From: Tim Townsend
Sent: 19 October 2018 13:55
To: Michael Eastham
Cc: Planning.Responses; David Lambert
Subject: LU/240/18/PL - Response to landscaping scheme (to be read-alongside WSCC Highways report dated 10th October 2018)

Further to my highways report of 10th October 2018, please find below comments in response to the landscaping scheme as submitted:

General tree pit detail
Scale 1:10

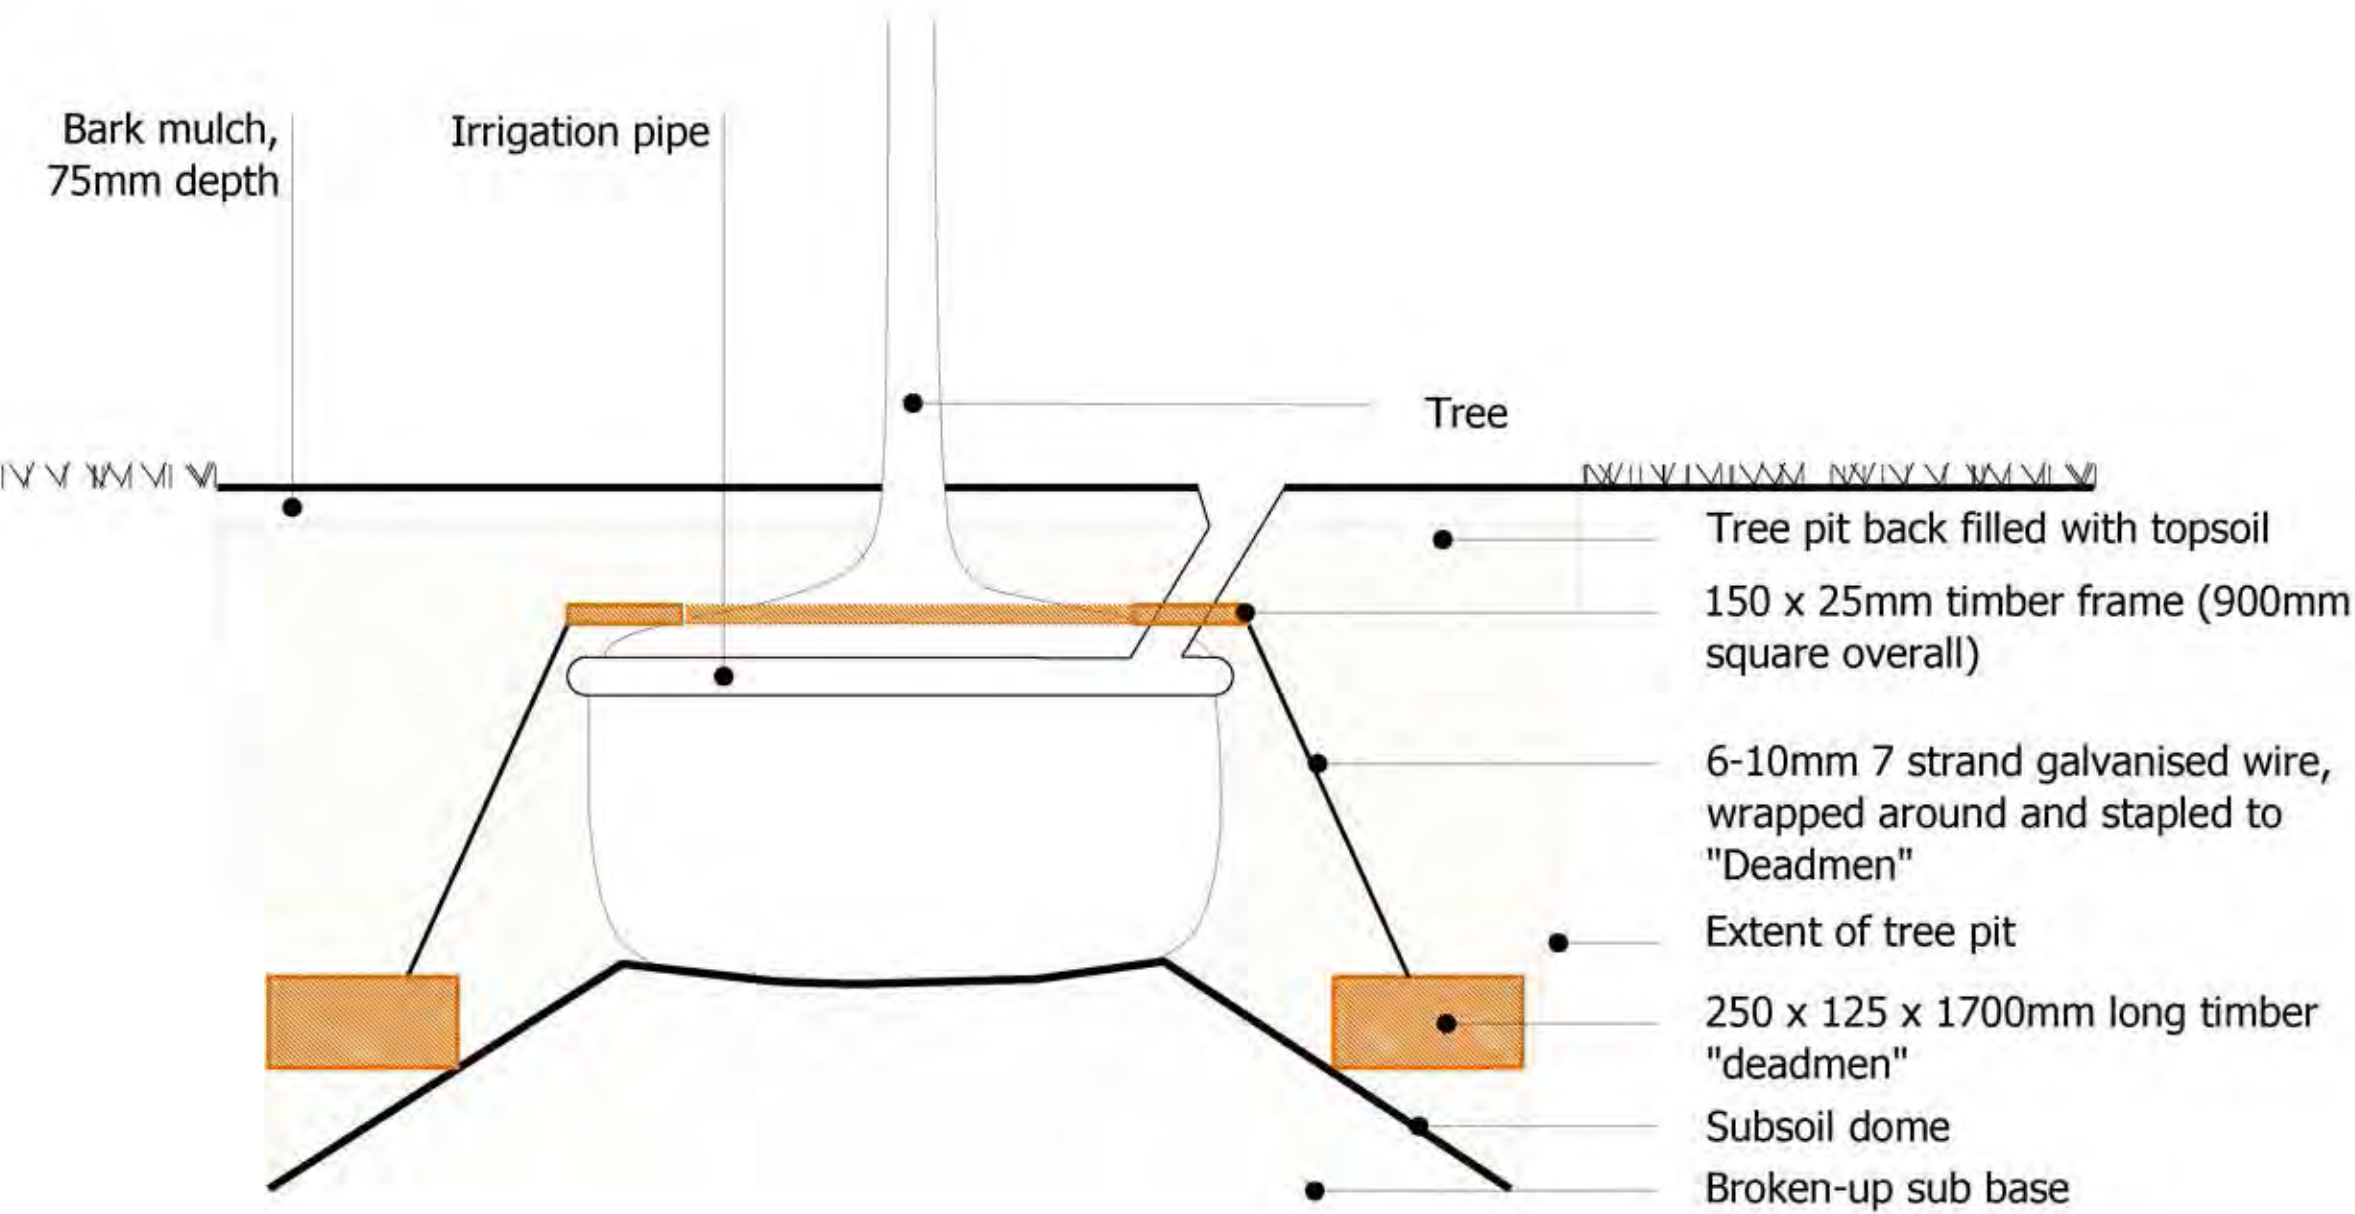
Re the general tree pit detail shown on LA108 – I know this is just a drawing but it is critical that the trees are not planted too deep. This drawing shows the root flare well below the surface. **Response required.**

Tree Planting Details **LA108 (RevN)**

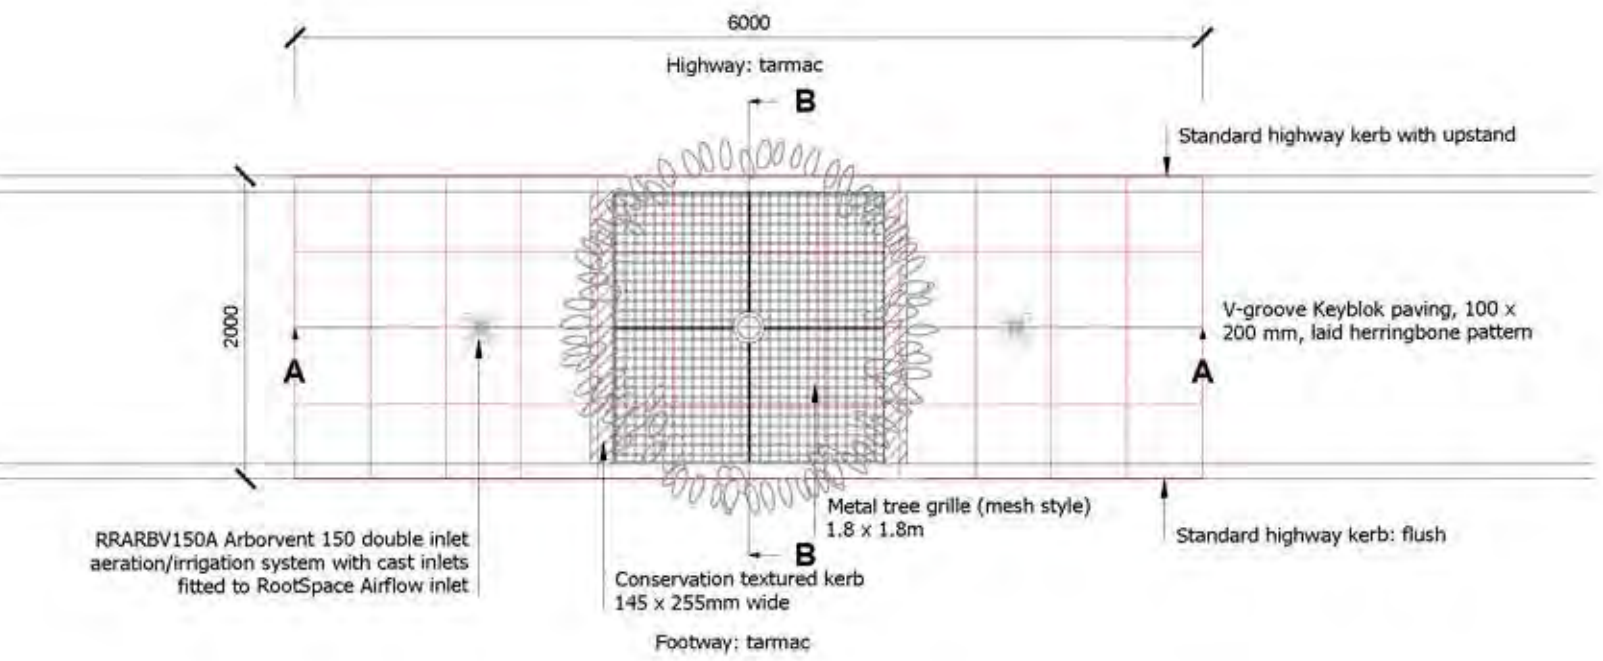
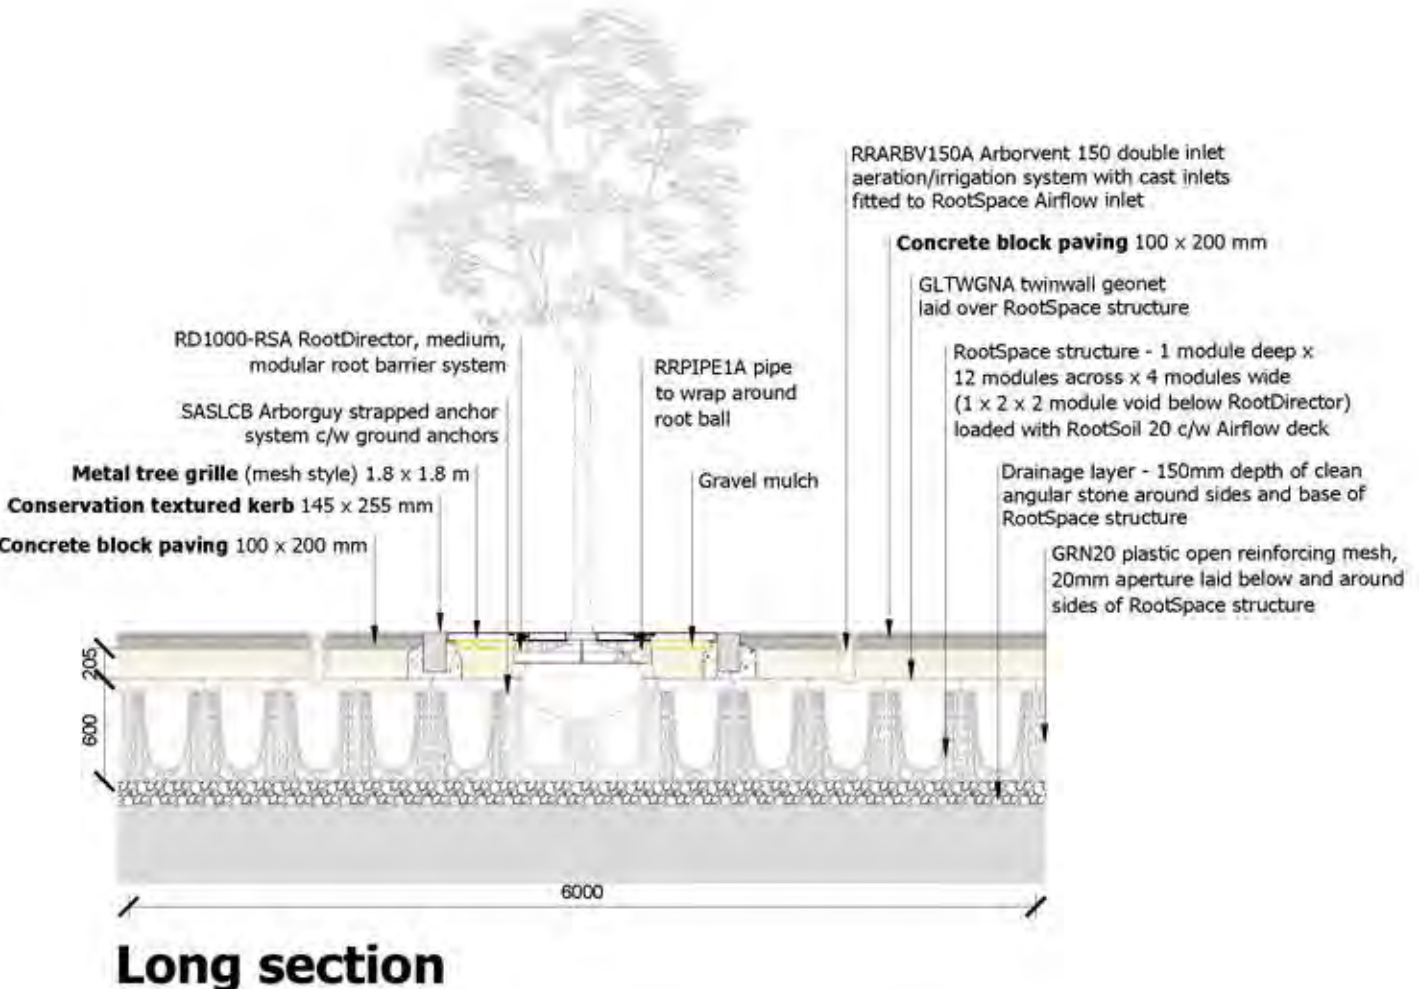
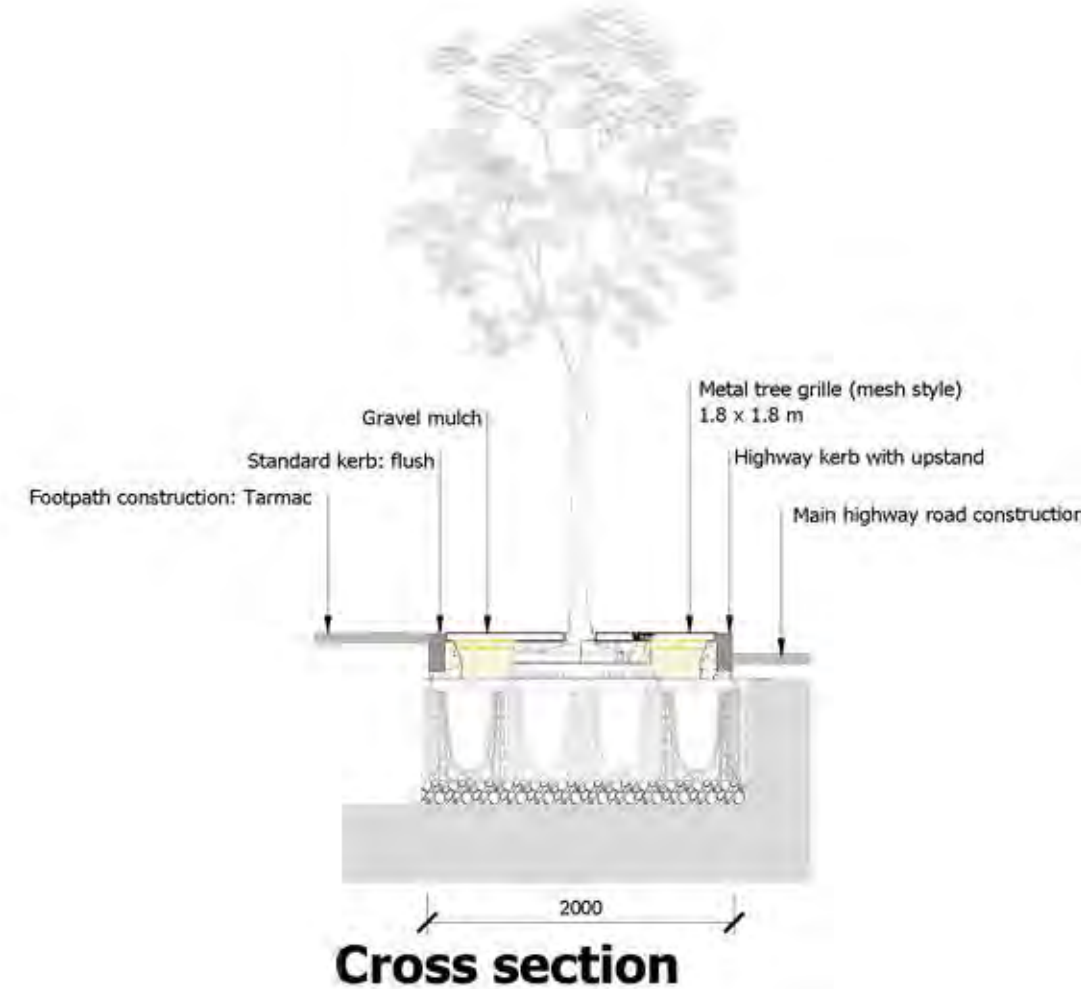
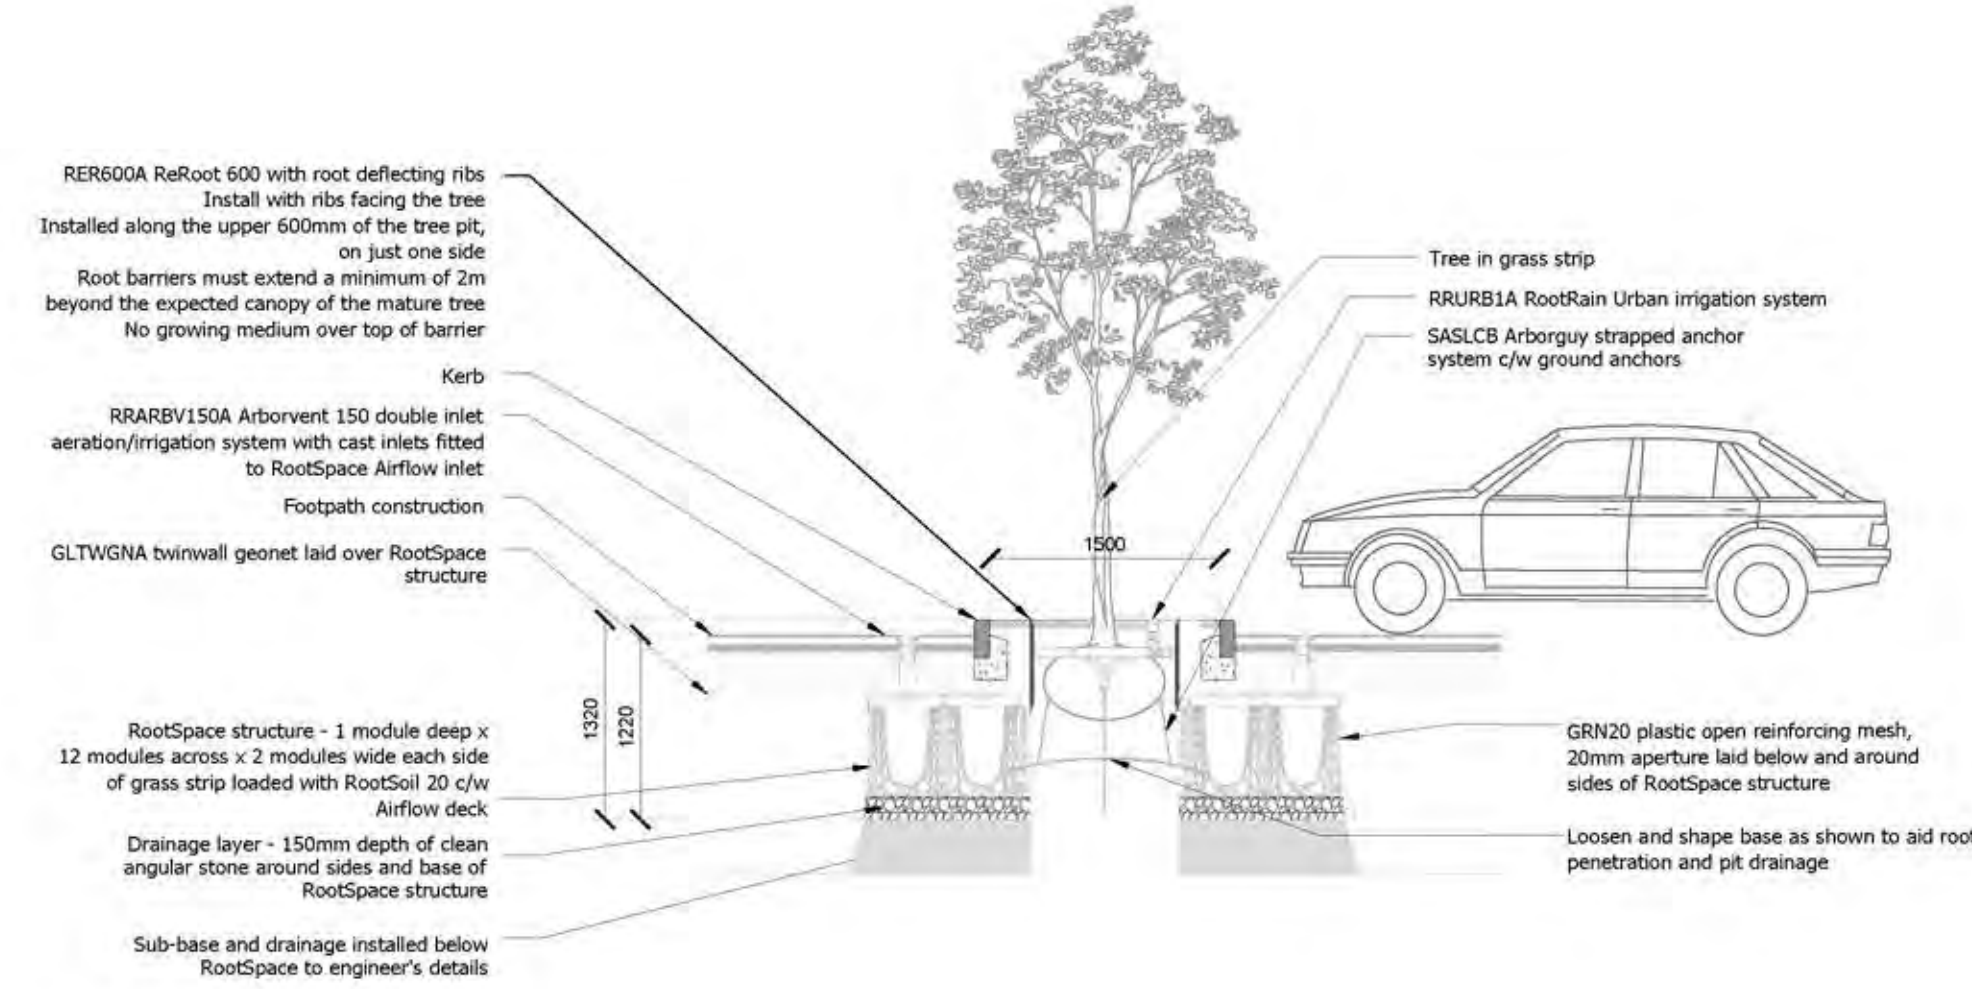
The tree planting details are fine – the use of soil cells: <https://www.greenblue.com/gb/type/soil-cells/> gives the required rooting volume whilst providing load bearing for hard surfaces, so it's almost a continuous rooting zone below ground. Storm-water management does not appear to be incorporated into the whole design (that would have been WSCC's preferred approach): <https://www.greenblue.com/gb/type/stormwater-management/> **Please respond saying why the design is as it is.**
